**The Victorian Group of the Oxfordshire Architectural and Historical  
Society**

**21/00278 – 1 Northmoor Road**

PROPOSED ELEVATIONS 01

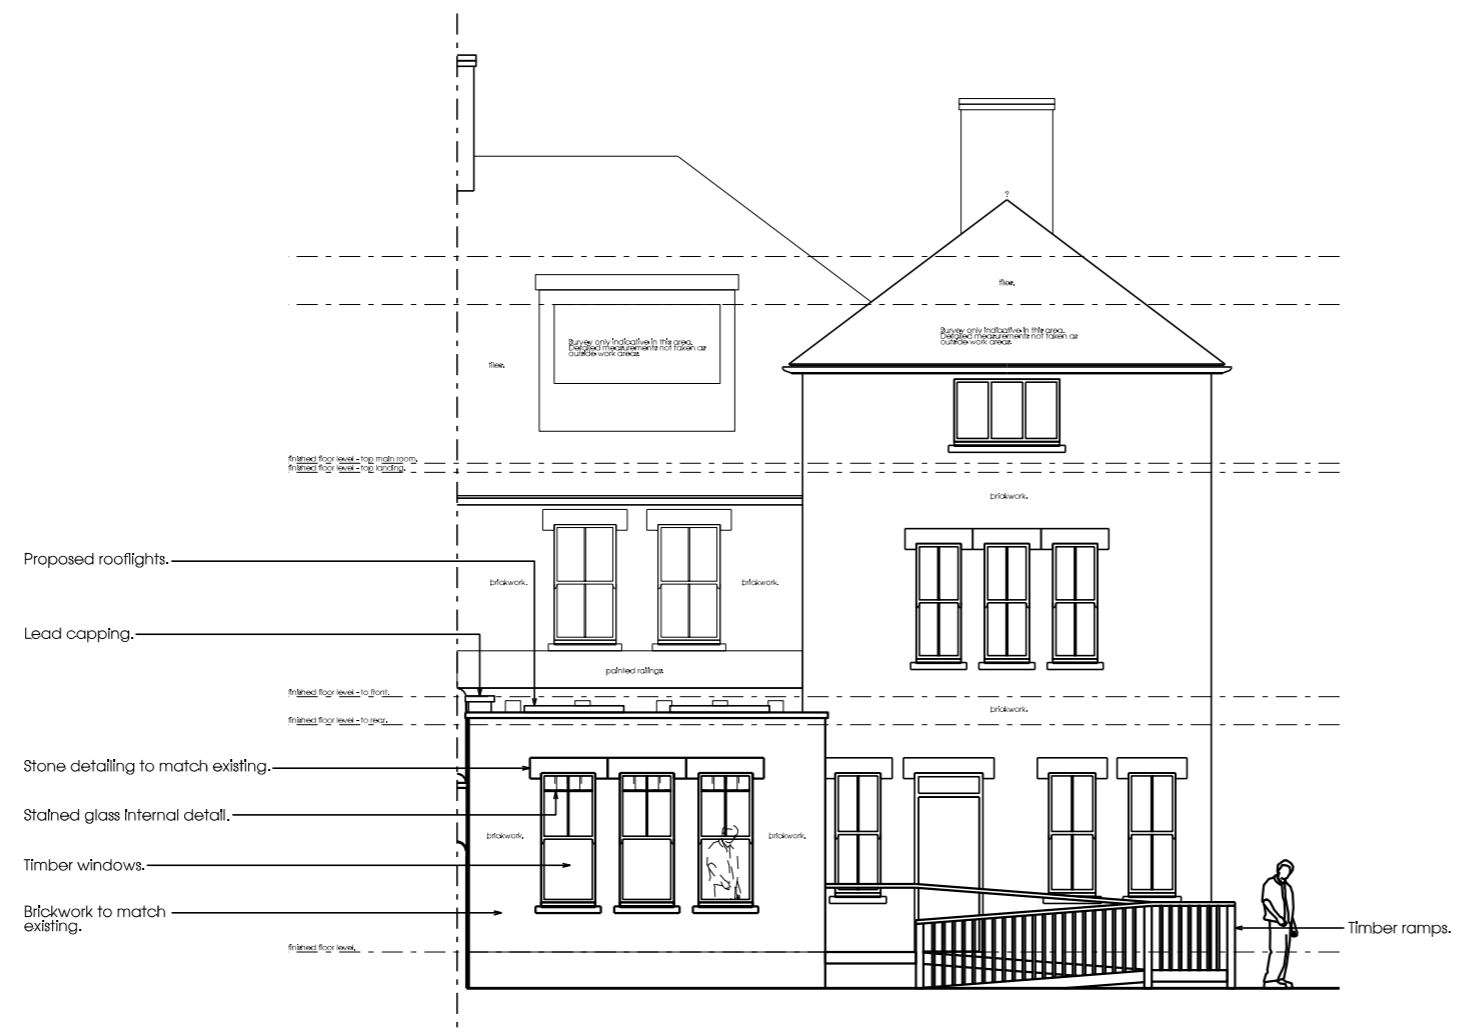
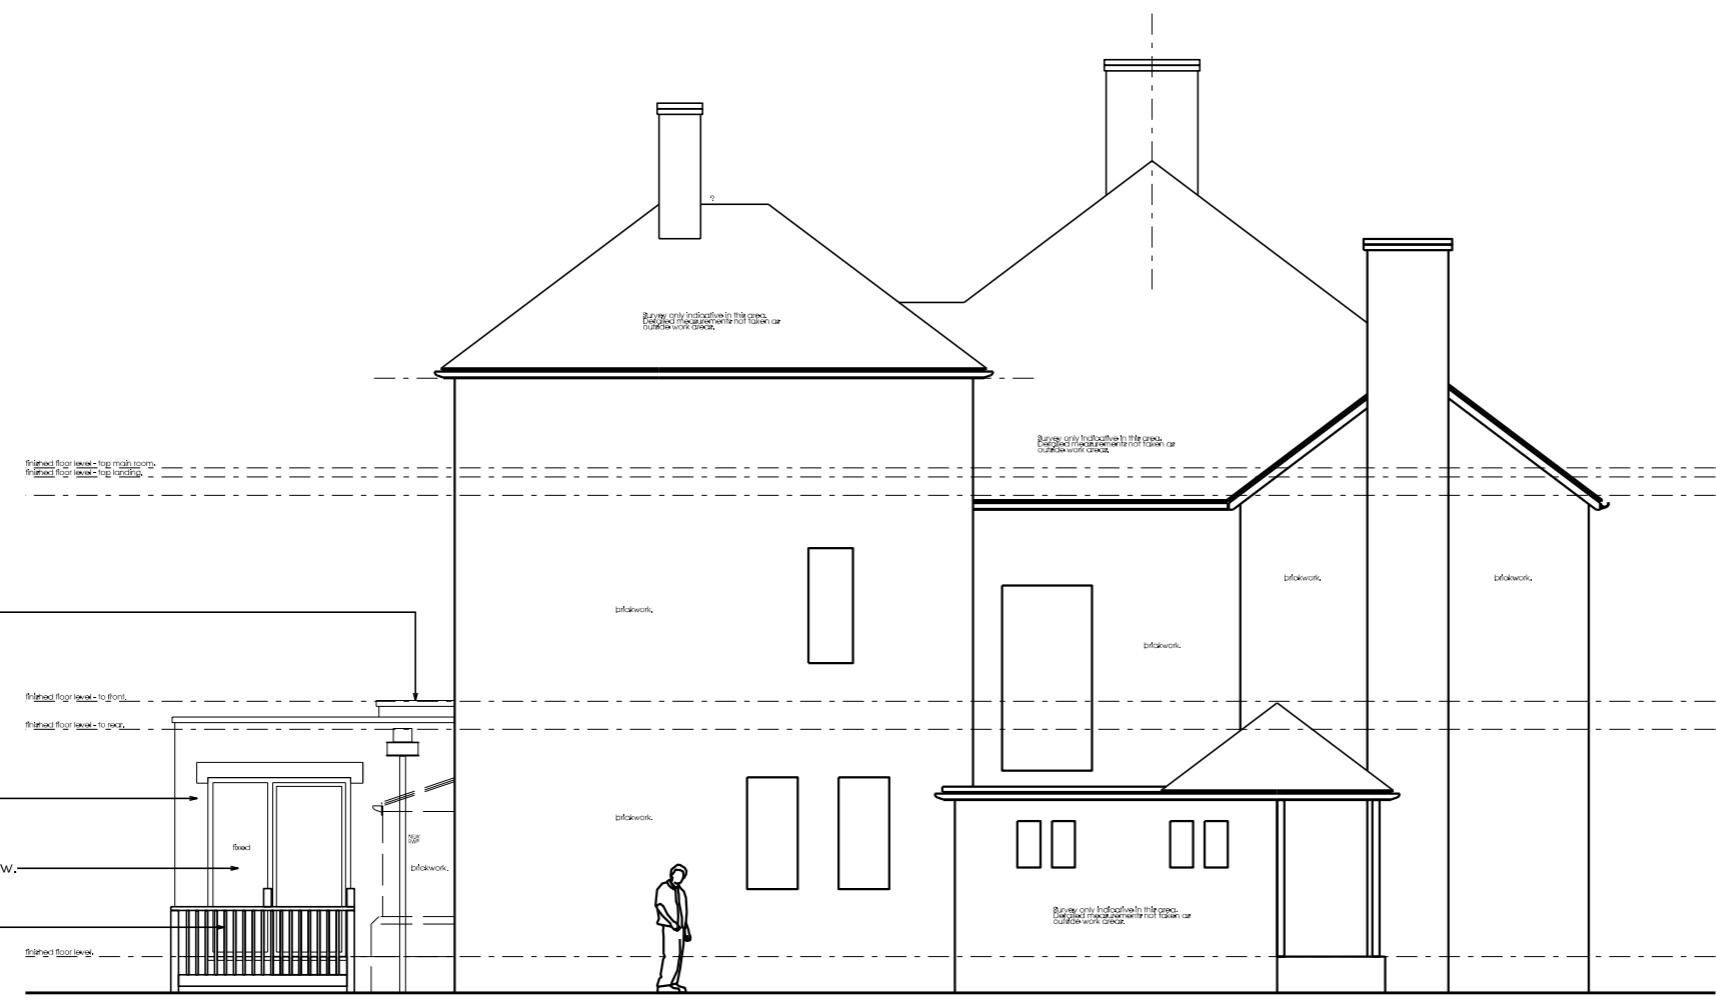
The proposed rear extension is a dismally unimaginative design, and would in no way compensate for the loss of the conservatory.
